Formal Planning Objection

Re: Planning Application 2026/62/90484/E – Change of Use from dwelling to C2 for 4 children, erection of first floor extension and front porch, internal and external alterations.

Property: 143 Church Lane, Gomersal, BD19 4QN

Proposed First Floor General Arrangement Plan 1:50

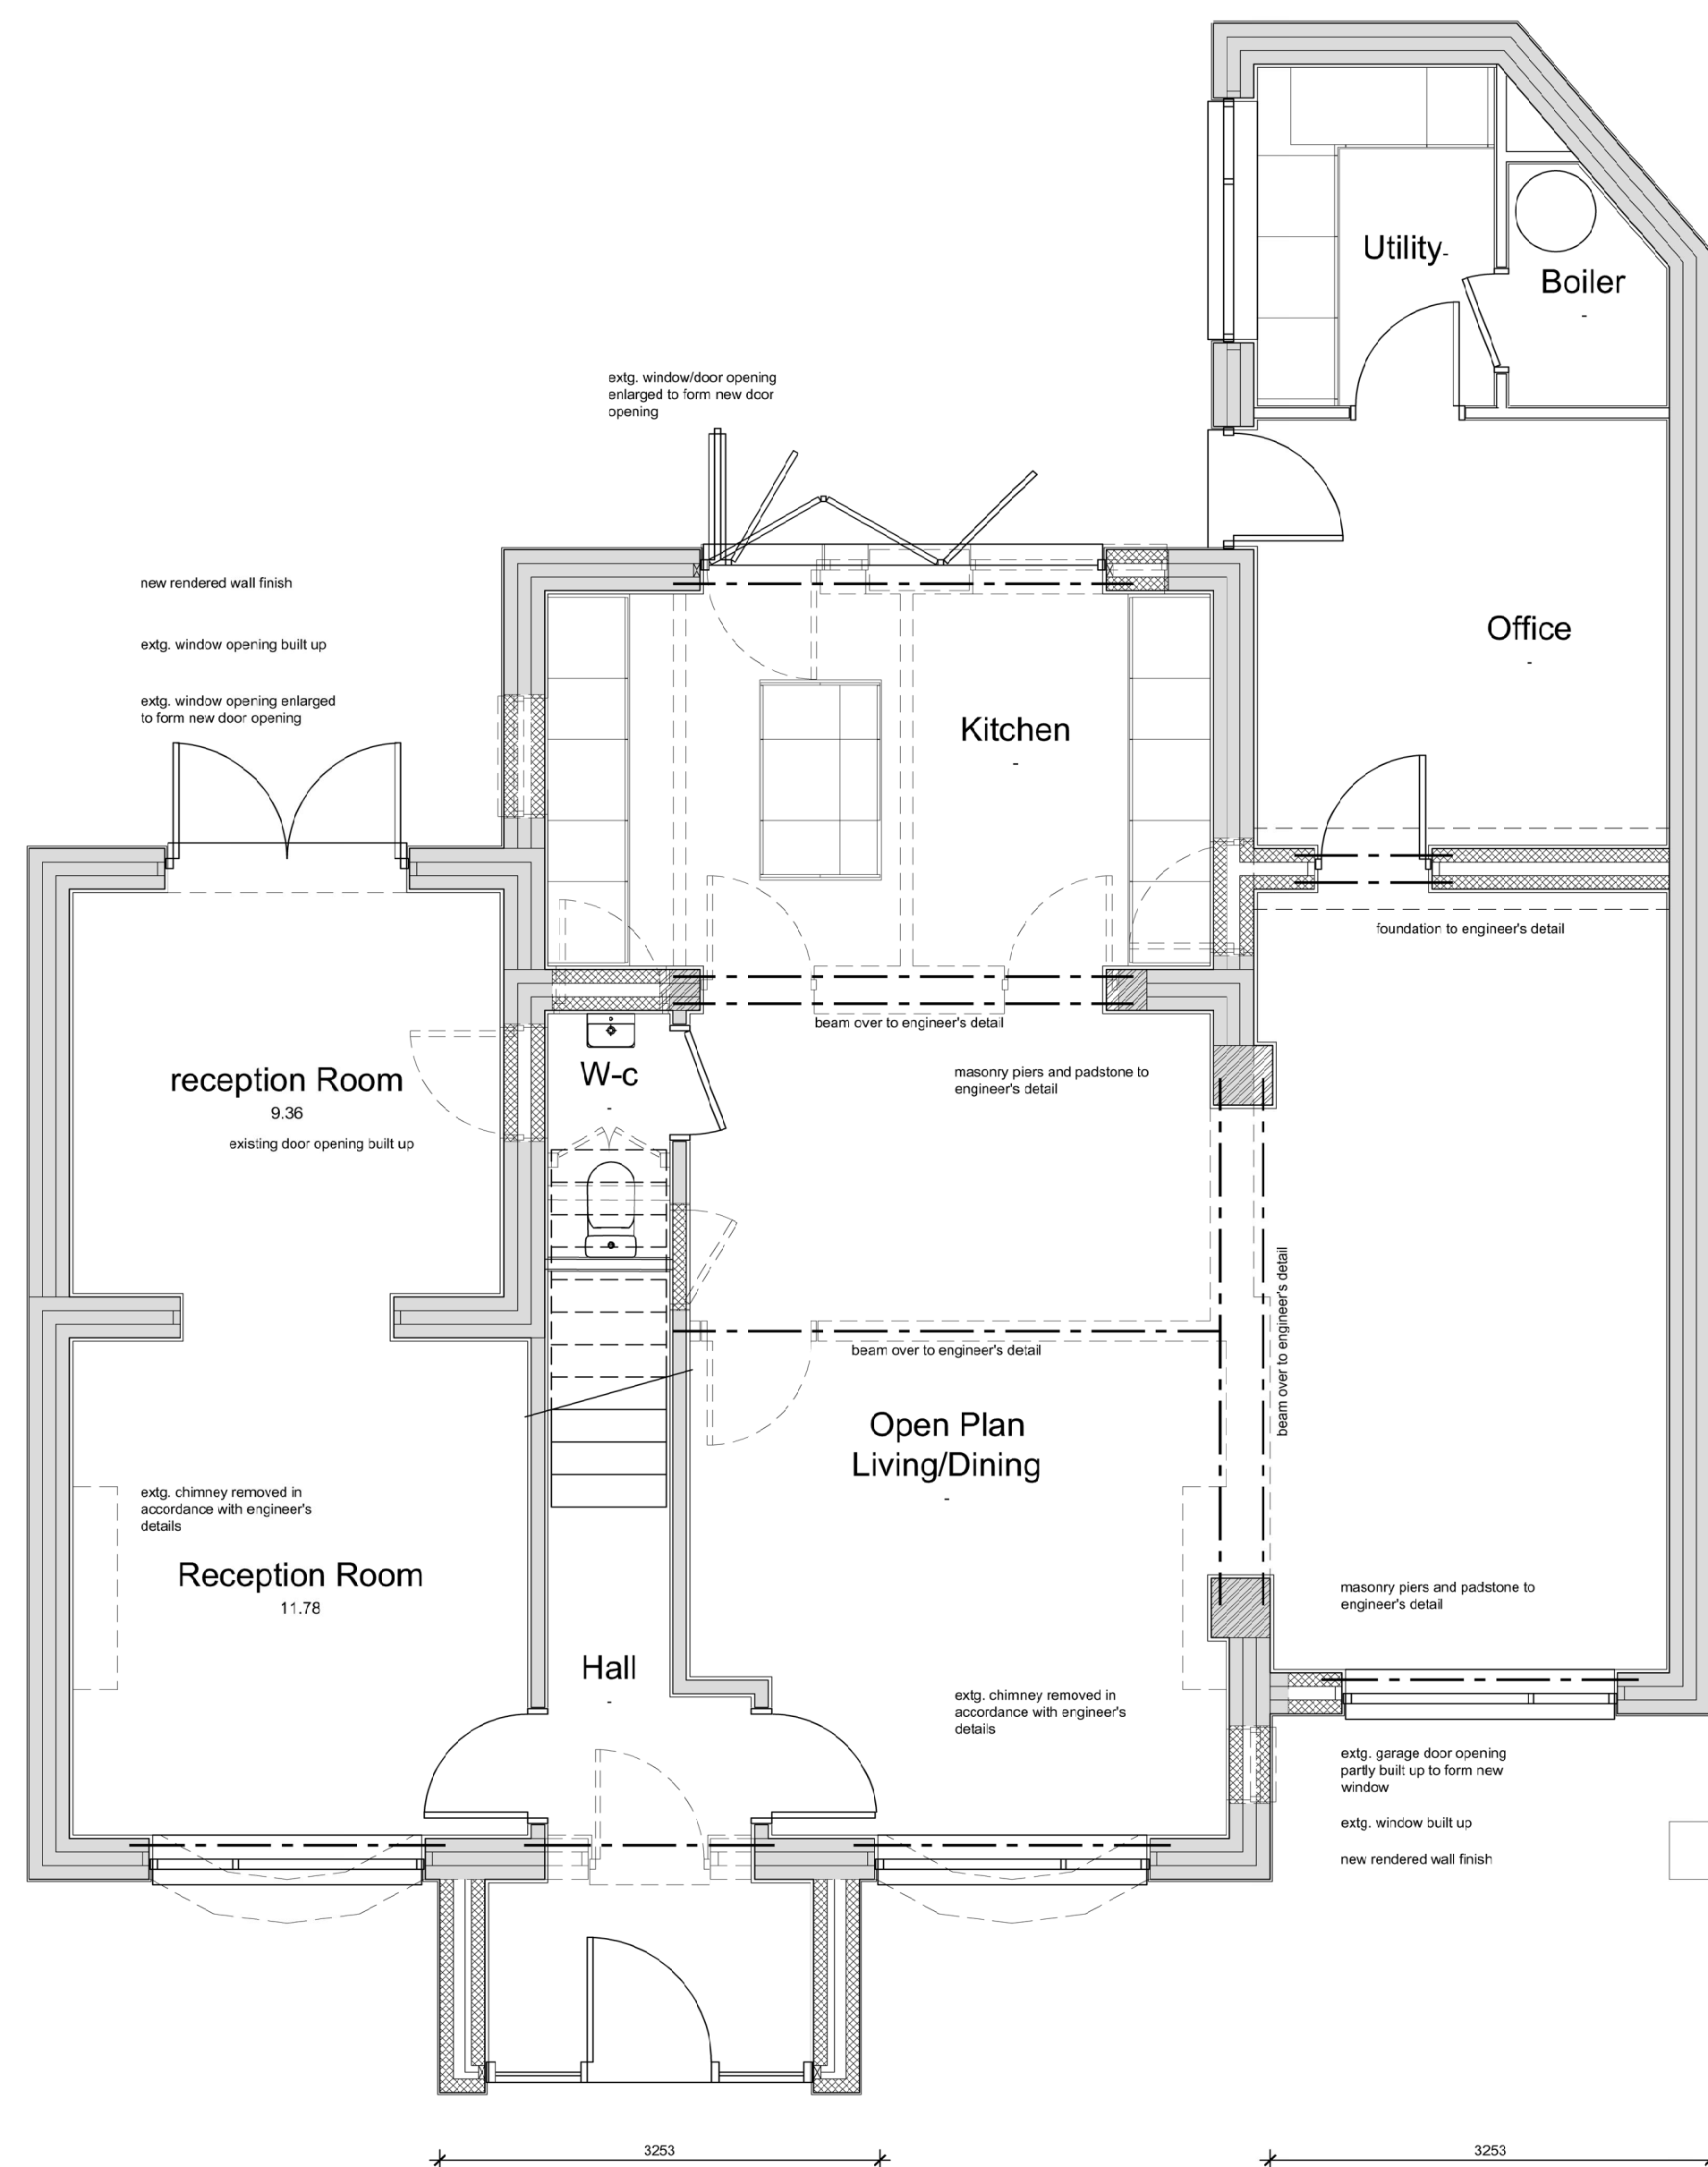
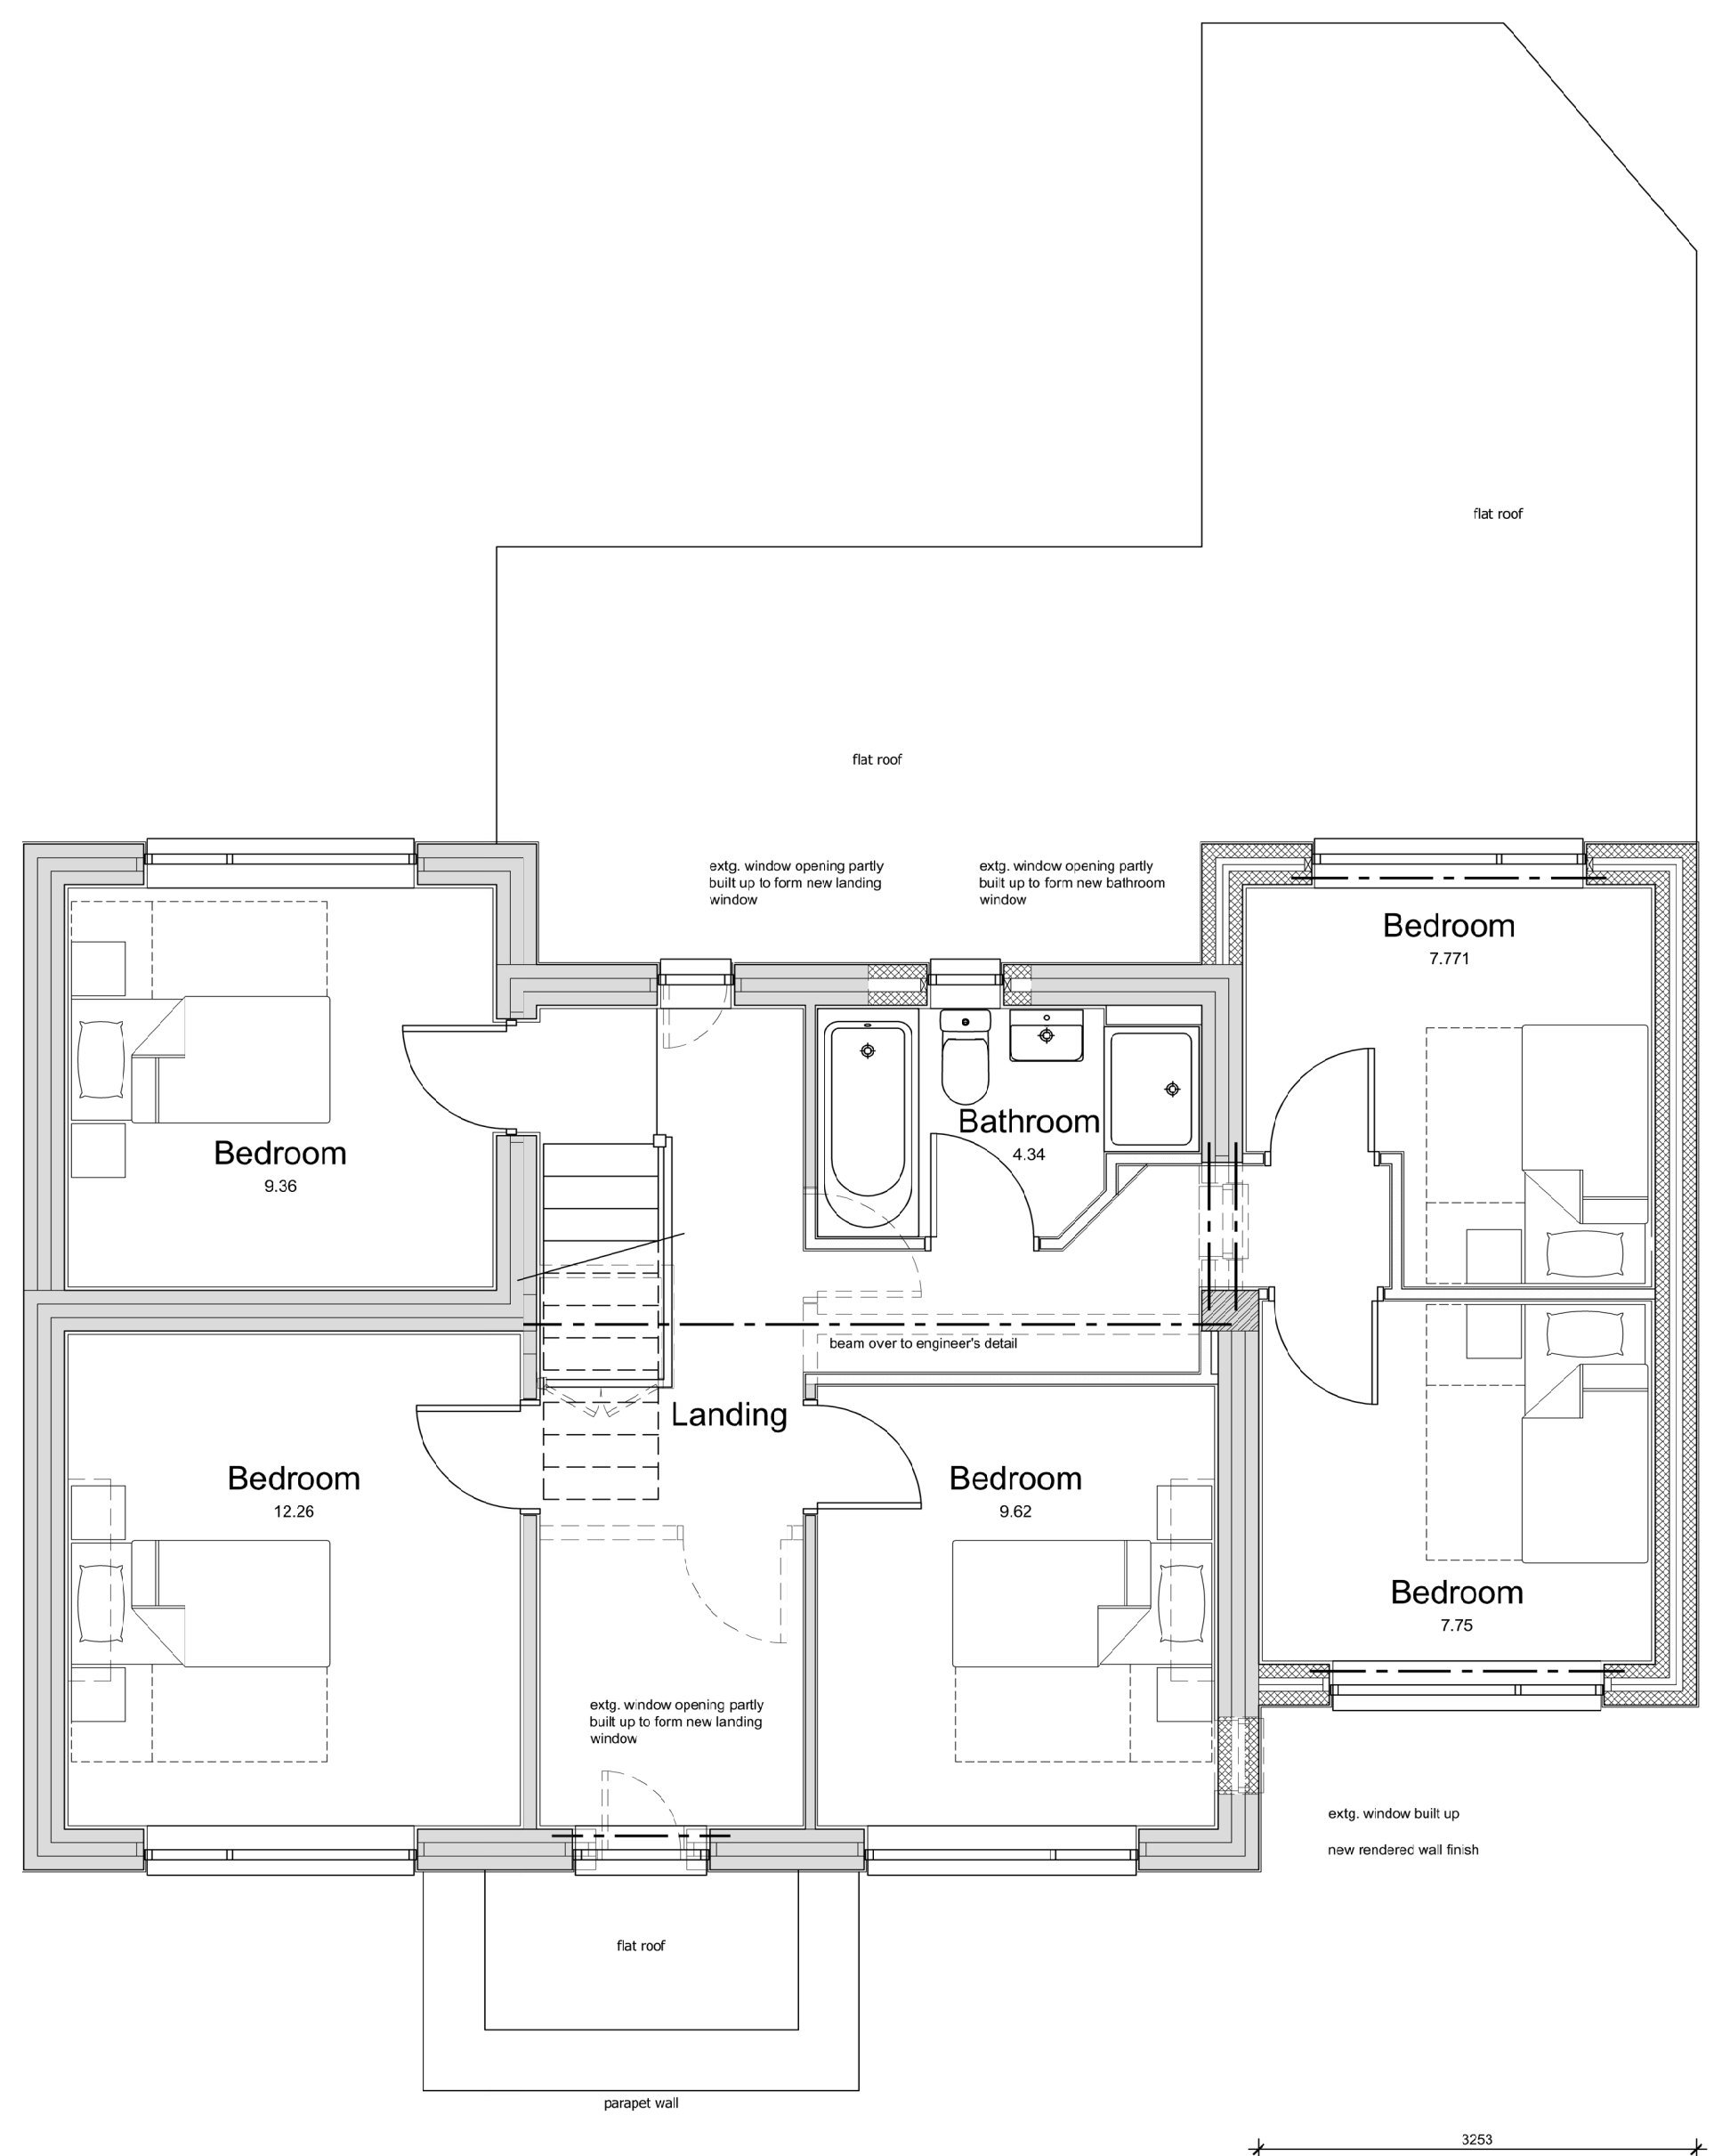
- Upper-floor windows that may function as fire escapes could allow residents to access a flat roof and exit the property.
- Boundary fencing between neighbouring properties is currently low and easily climbable.
- The property is located directly opposite a bus stop with frequent services to Huddersfield and Leeds.
